**KIRKLEES METROPOLITAN COUNCIL
INVESTMENT & REGENERATION SERVICE**

**DELEGATED DECISION TO DETERMINE APPLICATIONS FOR
CONSENT, AGREEMENT OR APPROVAL REQUIRED BY CONDITION**

Reference No:	2026/44/91835/W
Site Address:	Land adj, 3, Vernon Close, Edgerton, Huddersfield, HD1 5QE
Description:	Discharge of details reserved by conditions 11 (parking), 13 and 14 (site investigation) on previous permission 2025/90829 for erection of detached dwelling with detached garage
Recommending Officer:	John Holmes

DECISION – DISCHARGE OF CONDITIONS – SPLIT DECISION

Drawing Title:
Proposed Foundation Plan

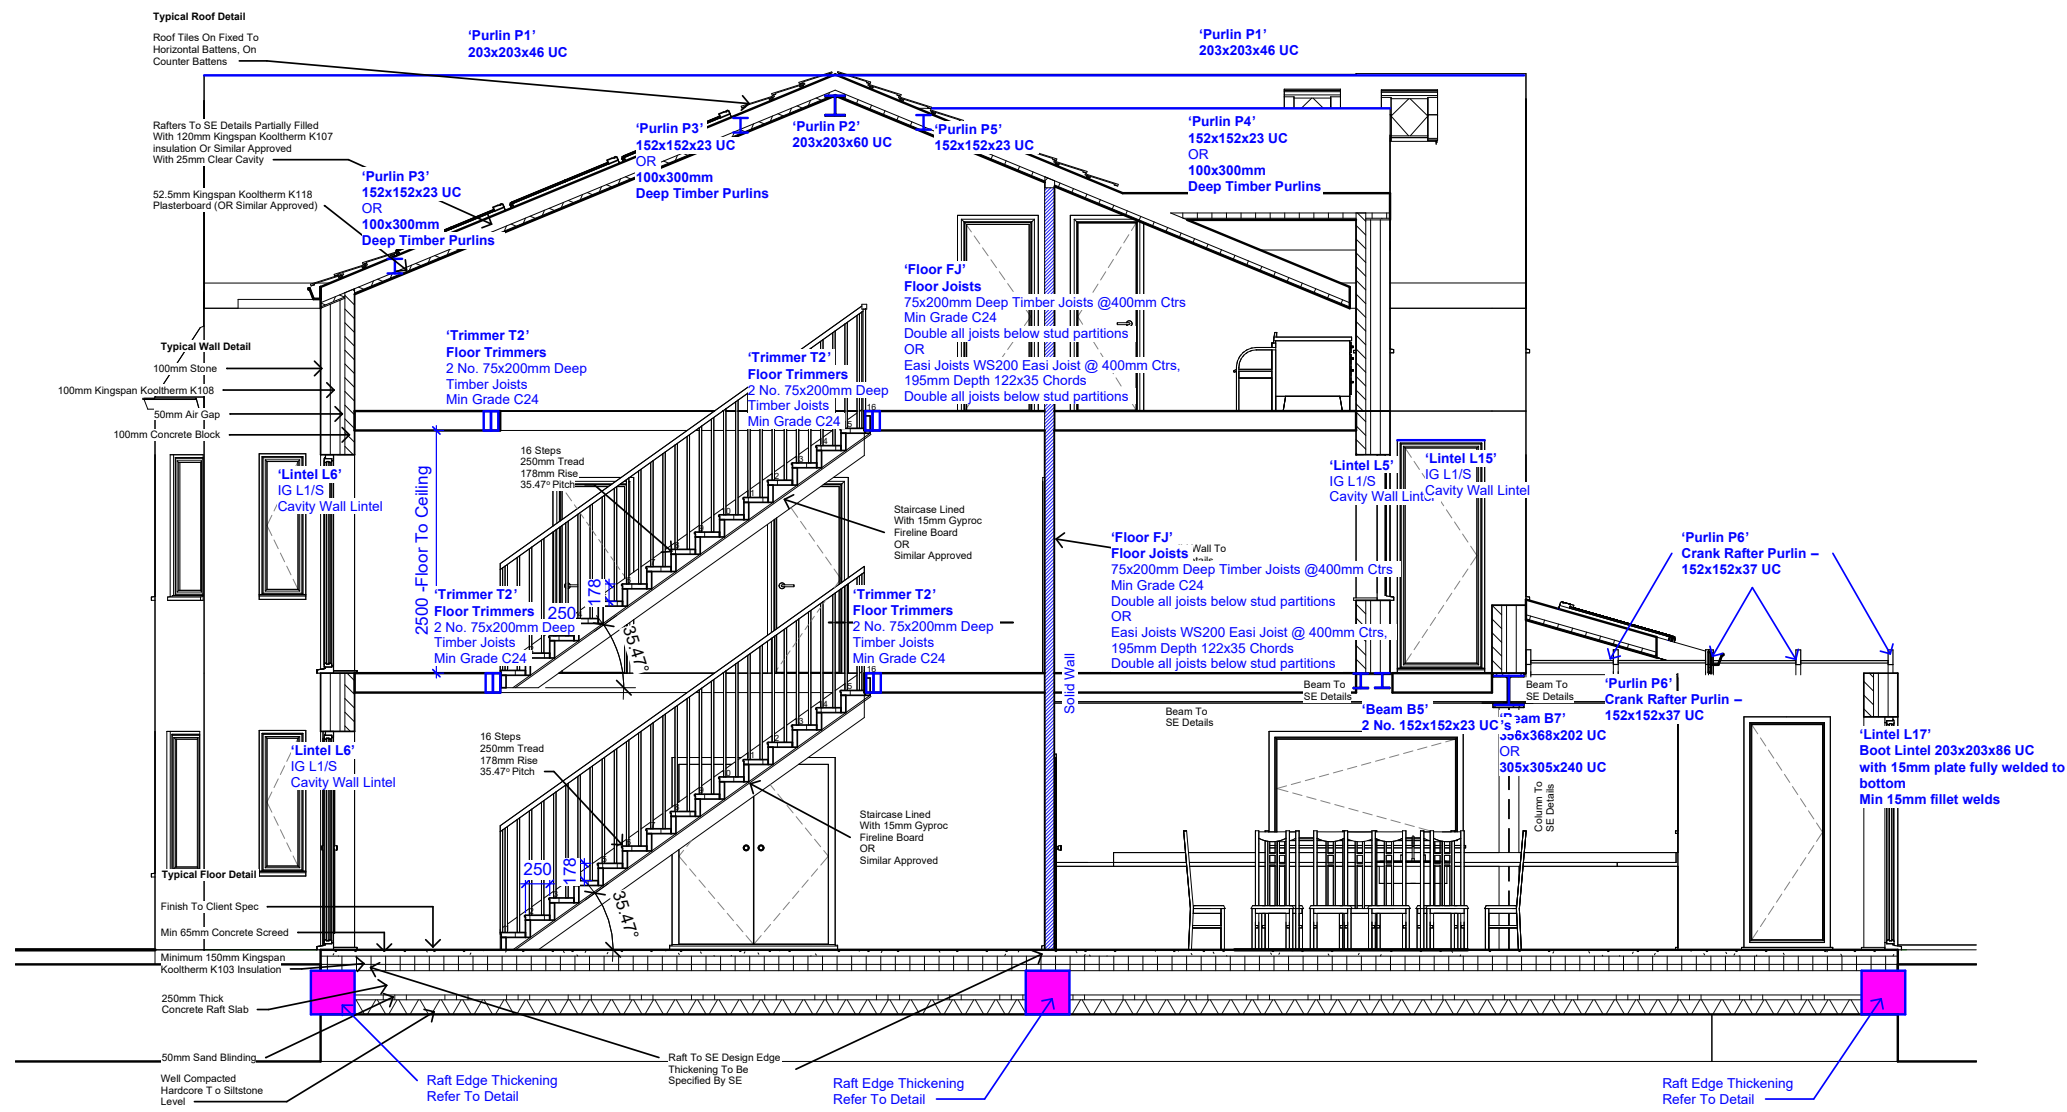
Nevertheless, in cognisance of the previous subsidence claim history in the locality, the report suggests that 'the appropriate mitigation is pressurised injection grouting to stabilise the Soft Bed Coal/mining horizon between depths of 16.5 to 19m to ensure the future stability of the ground beneath the footprint of the new house as well as the garage to the rear.' It advises that 'As a further measure consideration should be given to supporting both new buildings on reinforced strip footings.'

The report goes on to comment that 'Whether in light of the seemingly minor surface mining related damage that has historically occurred in the area and the clients alternative proposal to adopt raft foundations rather than grouting for both house and garage would be acceptable requires further consultation and reaching agreement with the Coal Authority on this alternative outcome.'

We note that the application is also accompanied by a subsequent letter report from Rob Palmer, Engineering Director at RGS, dated 26 February 2026. Following a review of the content and recommendations of the earlier Geoinvestigate Ltd report, Mr Palmer advises that 'grouting is a not necessarily a preferential option on this occasion' and comments 'In RGS' view, a raft foundation would be suitable in this instance. A sufficient cover of rock (competent overburden) is recorded to be present; coal workings will be at varied depth in the area, but are at a sufficient distance beneath the site in question; the working beneath the site also appear to have collapsed, thus further movement is unlikely; previous movement in the immediate area may be attributable to root damage, rather than the collapse of coal workings.'

Based on the information submitted and the professional opinions contained therein, in this instance the Coal Authority's Planning & Development Team would have no objection to the construction of the approved scheme of development with suitably designed reinforced raft foundations as a means of mitigating coal mining legacy related ground movement, in lieu of the drilling and grouting of the identified workings. However, no information has been provided to confirm that the recommended mitigation measures have been fully implemented. As such, we are currently unable to recommend that the LPA should discharge Conditions 13 and 14 of the issued consent.

Having regard to the submitted detail and response of the Coal Authority it is considered that on the basis all remediation works and/or mitigation measures to address land instability arising from coal mining legacy, as may be necessary, so identified in the submitted scheme have been implemented on

site in full, condition 13 is satisfied and discharged. Condition 14 is required to remain until such time that a signed statement or declaration prepared by a suitably competent person confirming that the site is, or has been made, safe and stable for the approved development has been submitted.
